Further to your letter of 19 August 2020, please find attached the comments of South Somerset District Council in respect of the further information provided by the Applicant in response to the issues identified in the Secretary of State's minded to refuse letter of 21 July 2020.

### Application by Highways England for an Order Granting Development Consent for the A303 Sparkford to Ilchester Dualling project

#### 9.44 Document 9.44 Highways England submission in response to the Secretary of State's letter dated 21 July 2020

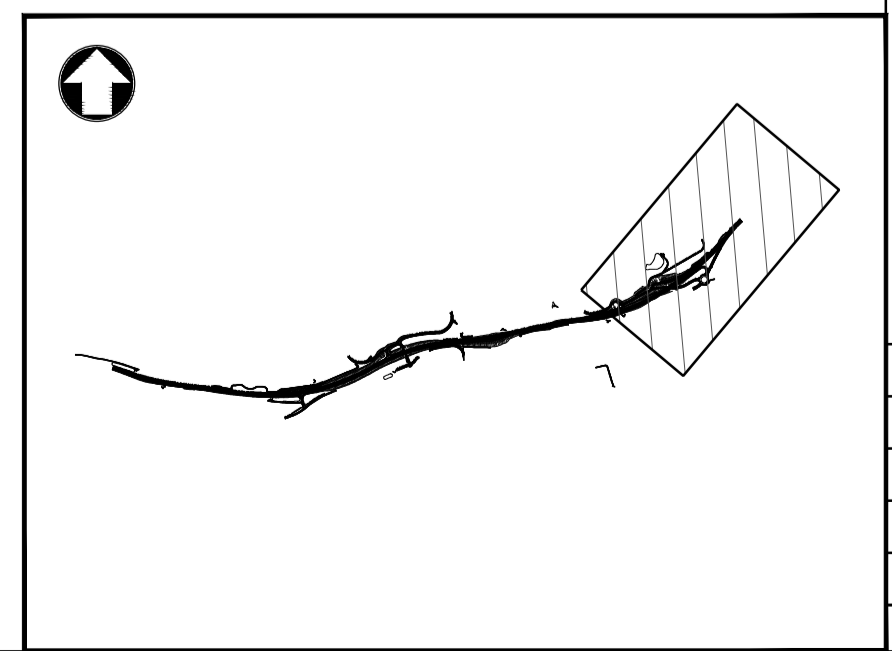
<p><b>6. Socio-Economic Effects on De-Trunked Road</b></p>	
<p>Paragraphs 6.3 10 - 6.3.29 - Lighting of the de-trunked A303 at Hazlegrove</p>	<p>South Somerset District Council agrees with the concerns raised by the Applicant in Document 9.44 regarding the potential for significant landscape and cultural heritage impacts from new highway lighting on the de-trunked road to deter anti-social behaviour. As highlighted by the Applicant, the landscape and cultural heritage impacts would be compounded when set alongside new highway lighting either side of the underpass, and vice versa. The Council would wish to make a full representation following the environmental impact assessment for this change to the DCO scheme.</p> <p>From an ecological perspective SSDC agrees with the concerns raised by the Applicant in Document 9.44. It is considered that new highway lighting would further increase the barrier to protected species which will be created by the construction of the dual carriageway. If lighting is required a revised impact assessment should be carried out on bat species and appropriate mitigation implemented, for example the use of red lamps such as those used in the Netherlands and on the A4044 in Worcestershire, these are invisible to bats.</p>

Drawing Title  
**FIGURE 12.4  
BUSINESSES IN THE LOCAL IMPACT AREA**

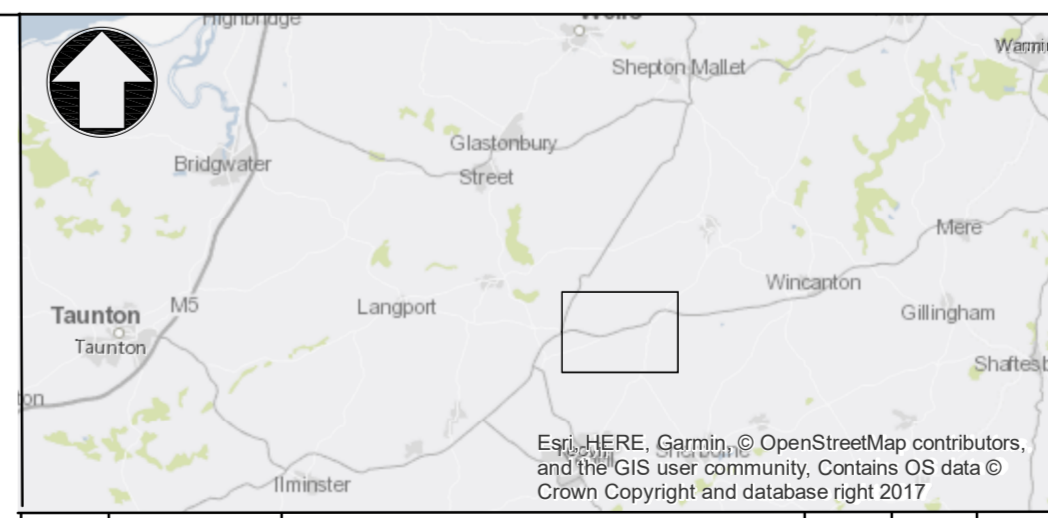
Paragraphs 6.3.30 – 6.3.35 and Annex F proposed amended signage strategy for local businesses	SSDC wish to confirm their support for the wider scale potential economic benefits of the proposed scheme but also wish to support existing local businesses where possible. To that end SSDC support the Applicants proposed amended signage strategy to include businesses on the former A303 (the Mattia Diner and Camel Hill Filling Station) as submitted with the applicant's response and shown in Annex F and Figure 6.3.
<b>7. Turning Heads</b>	No comment.
